Your Ref :
Our Ref : LU/228/17/NMA

Application for a Non-Material Amendment following a grant of planning permission LU/205/16/PL relating to buildings set at 1010mm from boundary & repositioned, extended amenity space, relocation of entrance to flat, changes to windows, internal alterations, changes to balcony support & change in windows & door materials to UPVc
C M Wood Body Repair Centre, Linden Park, Littlehampton,

DRAWING NUMBER	15160/01 R2

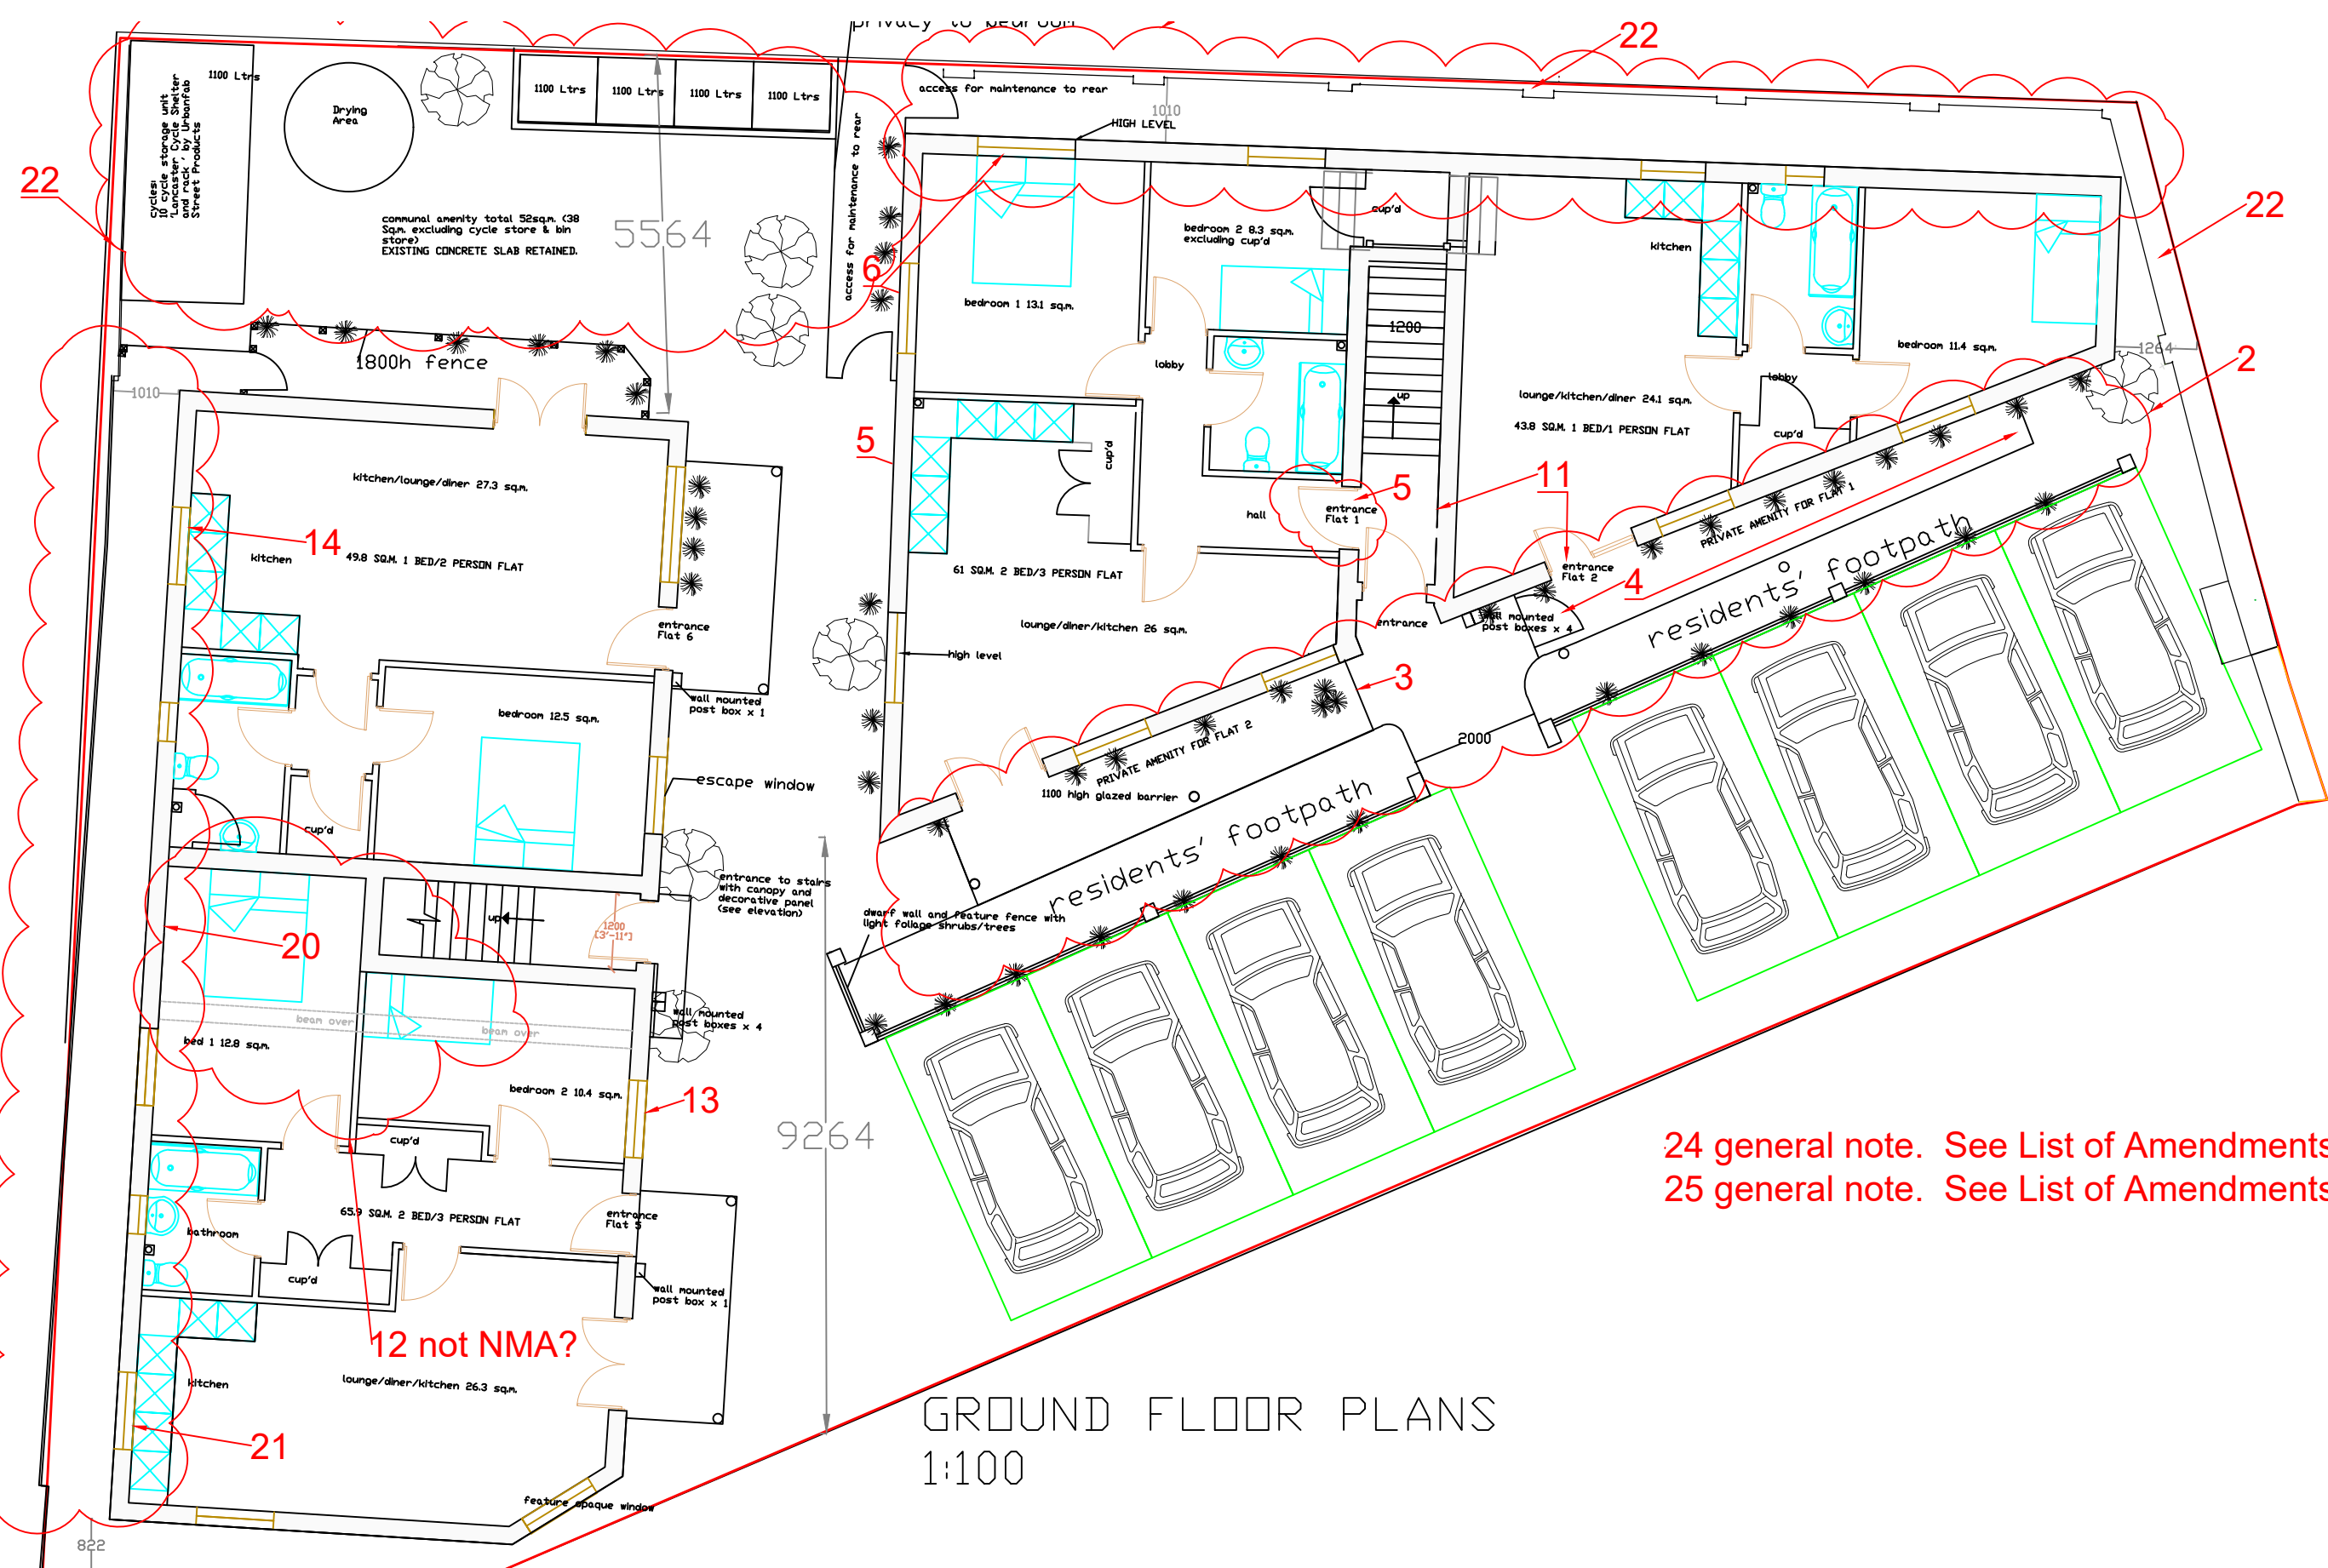
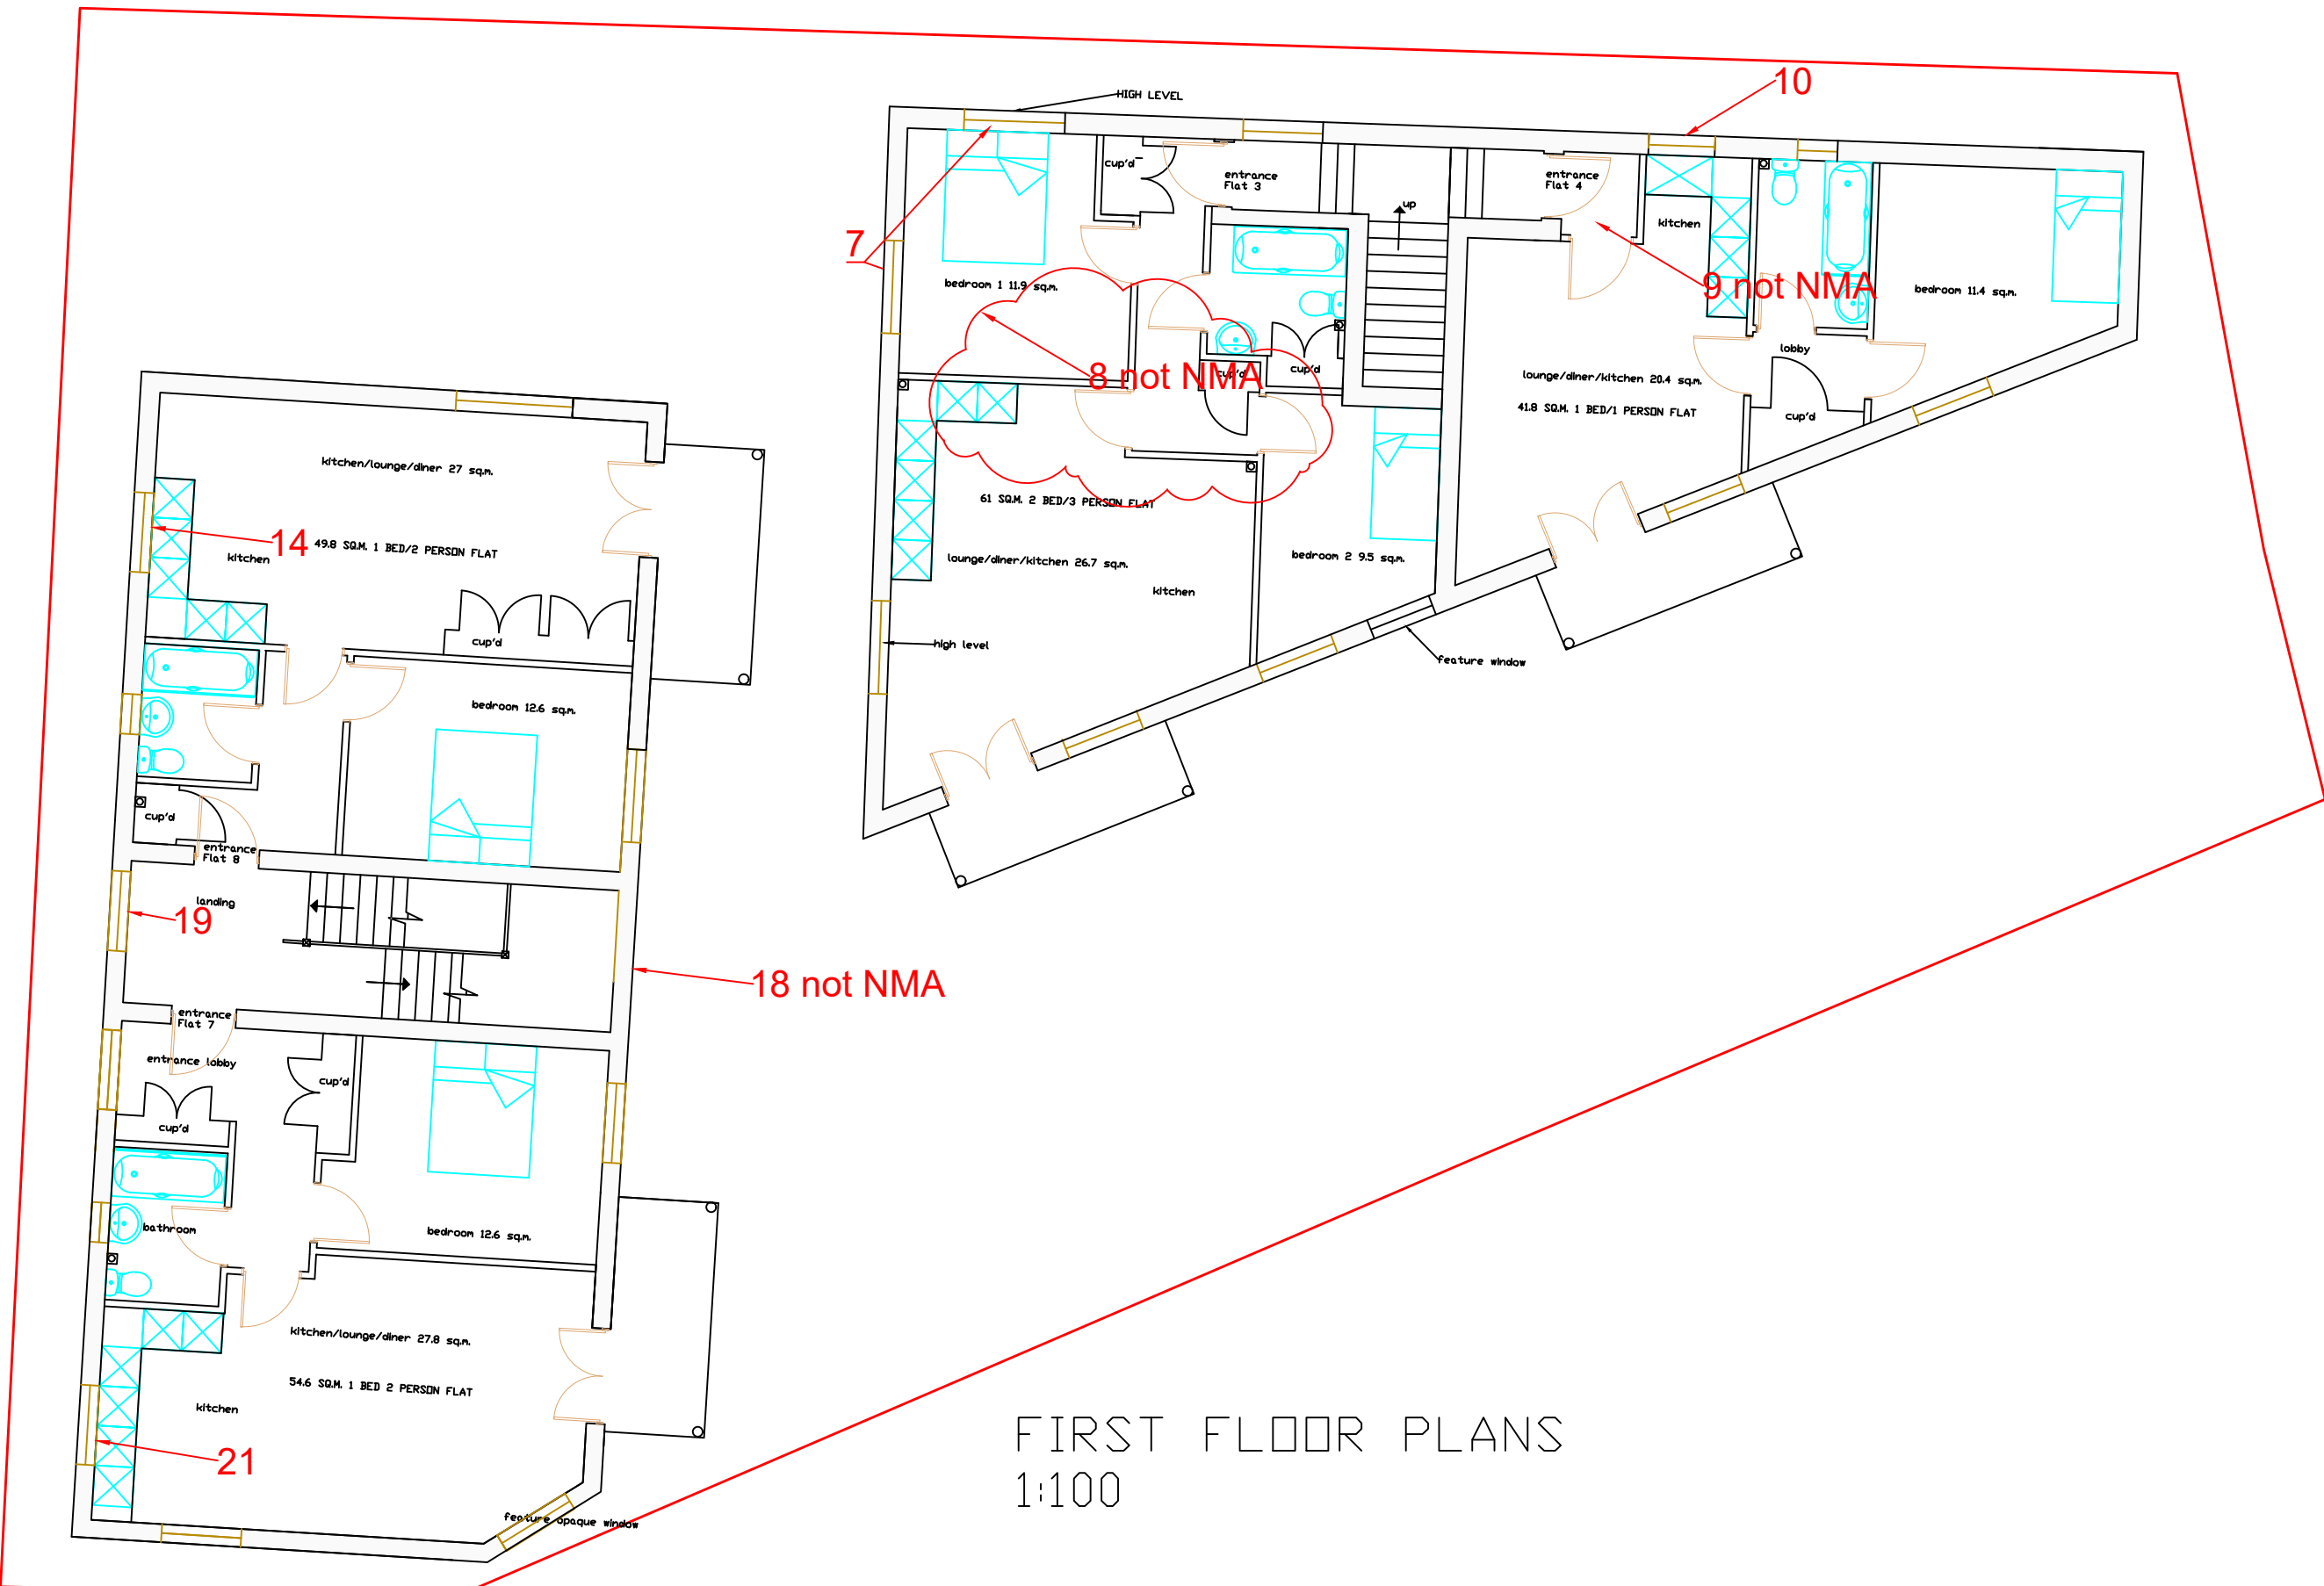
- Buildings moved further from site boundaries and re-aligned slightly to provide a gap to the boundaries of 1010mm from the boundary
 - Footpath moved and amenity space width reduced slightly to accommodate for moving building forward.

- Flat 1 - Amenity space extended to in front of window
 - Flat 2 - Amenity space extended and gate added for access
 - Flat 1 - Entrance to Flat 1 relocated to inside main entrance to facilitate improvements to internal layout. Original front door in South elevation removed.

- Flat 1 - High level window now in West elevation. Normal cill window in South elevation`
 - Flat 3 - High level window now in West elevation. Normal cill window in South elevation`

- Flat 4 - Kitchen window smaller (800 instead of 1200) and moved
 - Flat 2 - Internal entrance blocked off. Entrance now from East elevation and double doors changed to single door with full height side light

- Flat 5 - Window to bedroom 2 moved 250mm
 - Flats 6, 8, 10 - Window to kitchen area (far West) moved inward to East by 600mm
 - Balconies throughout. Added vertical supports to all outward corners.

- Block 1 (3 storey) Stairwell. FF landing window on ½ landing deleted.
 - Block 1 FF landing window to South elevation made bigger to match 2nd floor bedroom window

- Flat 5 Bedroom 1 - Small window deleted due to new internal layout
 - New windows to South elevation to Block 1, flats 5, 7, 9. New windows positioned in kitchen.

- Retained walls now shown on Site Plan to North boundary. Originally the walls were to be removed and replaced with fencing. It is now proposed to retain the flint wall to this boundary as well as part of the building wall which is attached to it. It is felt this adds to the security of the site.

- Communal Amenity Space to put bin store more accessible to residents and collection operatives.
 - All windows and doors to be UPVc. The Application stated grey Aluminium

- Accordingly drawings 15160/01 r2 Proposed Site Plan, 15160/07r2 Site showing Boundary Treatments and Indicative Landscaping and 15160/04r1 Proposed Elevations have become the approved plans.
